Prospect Logistics Estate Submission

I strongly object to the State Significant Development titled Prospect Logistics Estate (SSD-10399) proposed on the land adjacent to the Prospect Hill Heritage Reserve. The location of this proposed beverage warehouse or distribution centre is not consistent with the adjacent land use and does not need to be located on this site for any reason whatsoever.

1 BUILDING 2 EAST ELEVATION 1 : 250

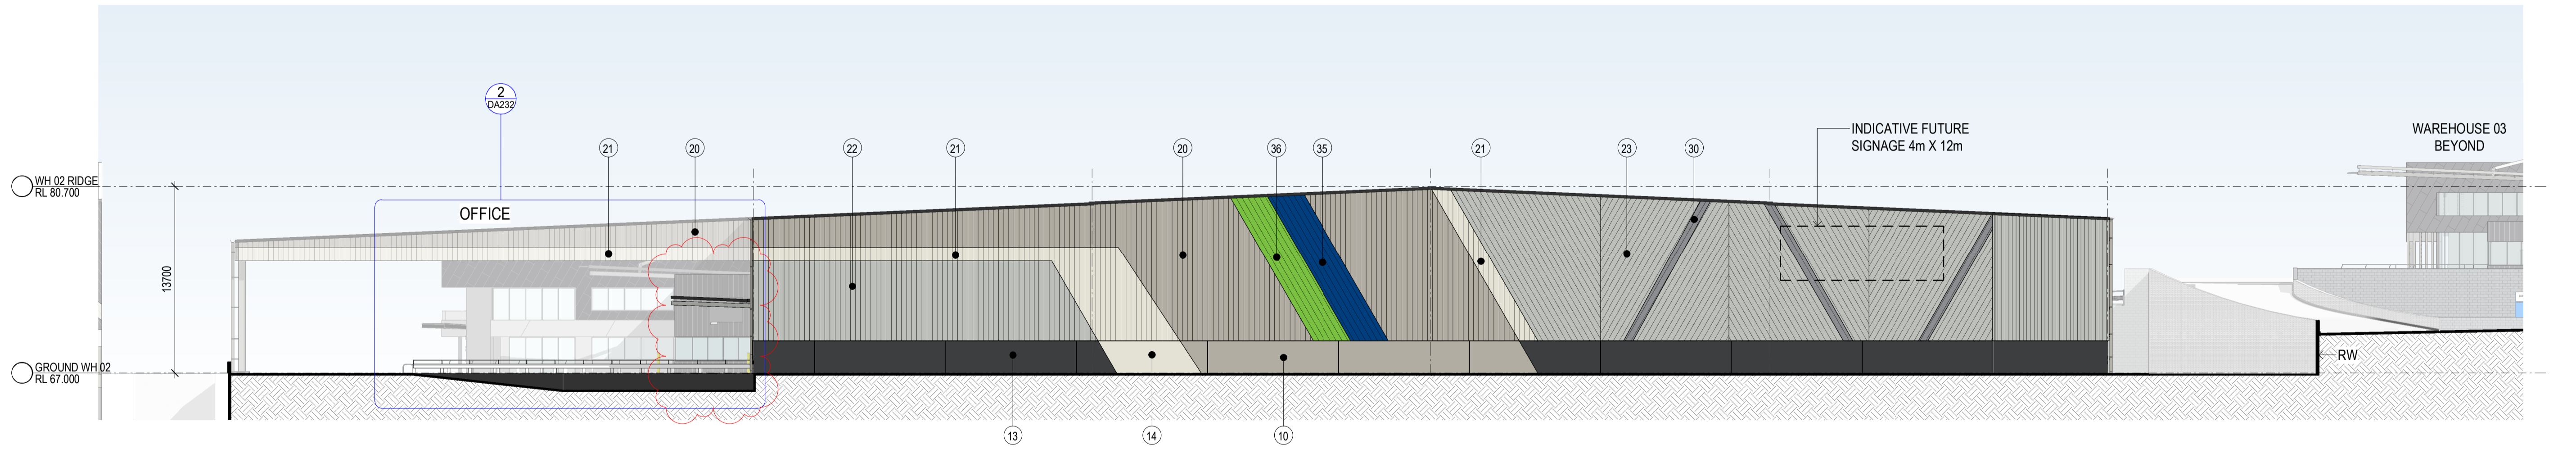
These critical principal development standards have not been met in this proposed development. The 42 metre high warehouse is proposed to be located across the road to residential properties and has been accompanied by ‘artists impressions’ in the Landscape Plan (<https://majorprojects.planningportal.nsw.gov.au/prweb/PRRestService/mp/01/getContent?AttachRef=SSD-10399%2120200819T015355.904%20GMT>) showing trees of over 20 metres in height forming a buffer between the residential back yards and the 42 metre height warehouse. These trees currently are not in existence and so will take 40+ years to reach the height needed to buffer the sight of the warehouse. This development that is equivalent in height to a 10-storey building will definitely have an impact on the adjacent residential area.

The residential houses on Muttong Street that back directly onto Clunies Ross Street are well within 250 metres of the proposed development. The proposed buildings will not be '*compatible with the height, scale, siting and character of existing residential buildings in the vicinity*'. The proposed '*elevation of any building facing, or significantly exposed to view from, land on which a dwelling house is situated*' has not '*been designed to present an attractive appearance*', and will be a 10 storey eyesore from the backyards of those living on Muttong Street, and also be a huge eyesore from the new dwellings on the south end of Clunies Ross Street, and the western end of Wombat Street. From the plans shown, the 42-metre-high warehouse will be an eyesore from a large area of Pemulwuy and Greystanes, not to mention Prospect and further afar.
